**Sydney Harbour
Foreshore Authority**

REF: SSD 7388

**Re: REDEVELOPMENT OF THE IMAX THEATRE AND SURROUNDING PUBLIC
DOMAIN, DARLING HARBOUR (SSD 7388)**

Figure 1. Public Domain areas key plan

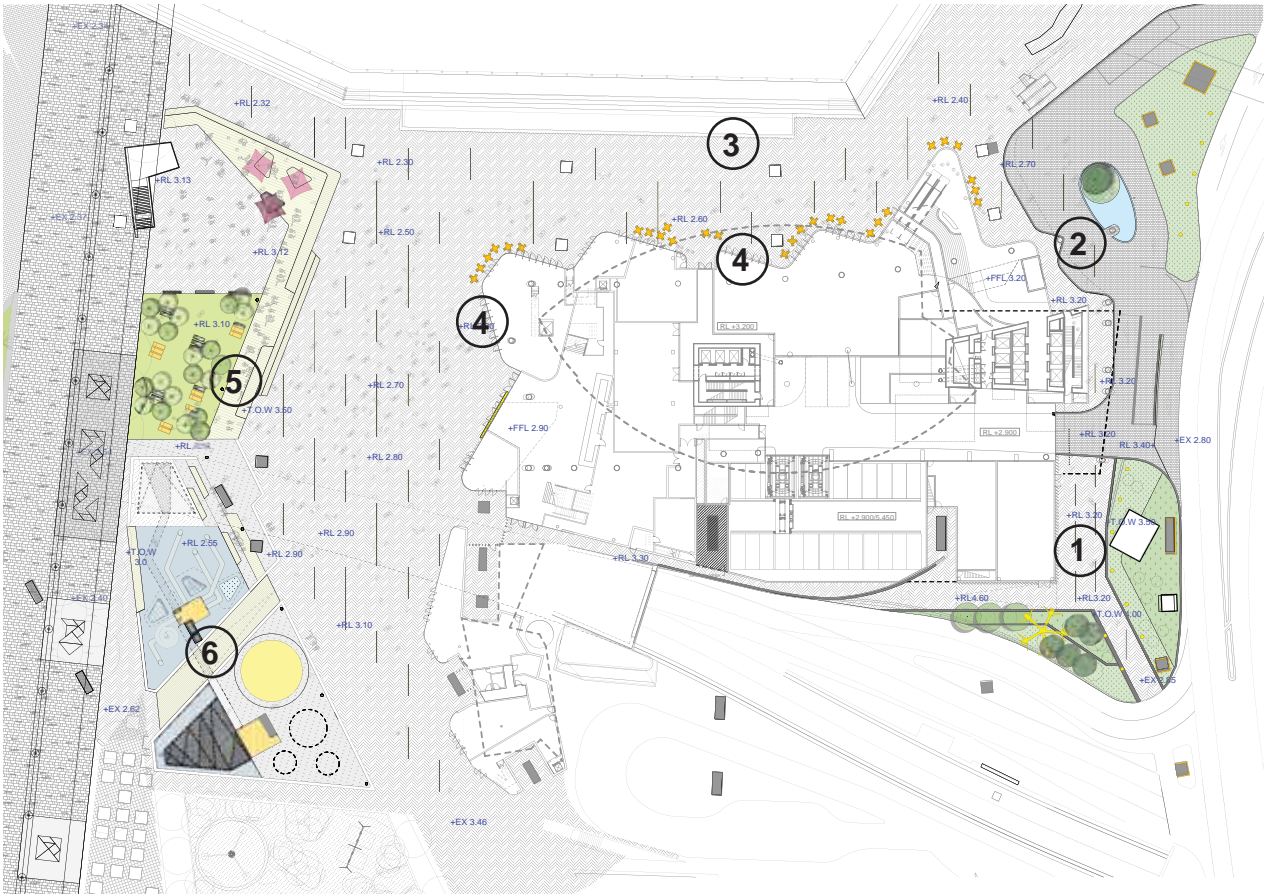
The proposed landscape plan, as lodged, prepared by Aspect Studios suggests that the existing cabbage palms create a visual blockage from Darling Quarter to Cockle Bay and therefore a proportion of them should be relocated and tightly grouped on the western edge of the site to ensure that the circulation space will be 'uncluttered' and fully open.

The original purpose of the cabbage palms in Darling Harbour when they were first planted has always been to reduce the visual and physical impact and the dominant scale of the overhead Western Distributor that bisects Darling Harbour by scattering the palms throughout the public walkway so they resembled an open forest of palms. The cabbage palms have quite narrow trunks and high canopies and it was always considered their visual impact was modest.

Although understanding the argument that the removal of the palms to an alternative location opens up the vista of Cockle Bay, the Authority is concerned that any significant reduction and relocation of the existing cabbage palms would allow the Western Distributor to once again become a dominant element within Darling Harbour and this would be unfortunate.

As indicated previously the Authority is working closely with the proponent to re-examine this component of the public domain design and suggests that the existing cabbage palms be retained in some form of a scattered layout but, at the same time, reduce any perceptions of visual blockage on the valley floor. The retention of the cabbage palms in a scattered layout would ensure the seamless integration of the new upgraded IMAX public domain with the surrounding area to create a more congenial landscape.
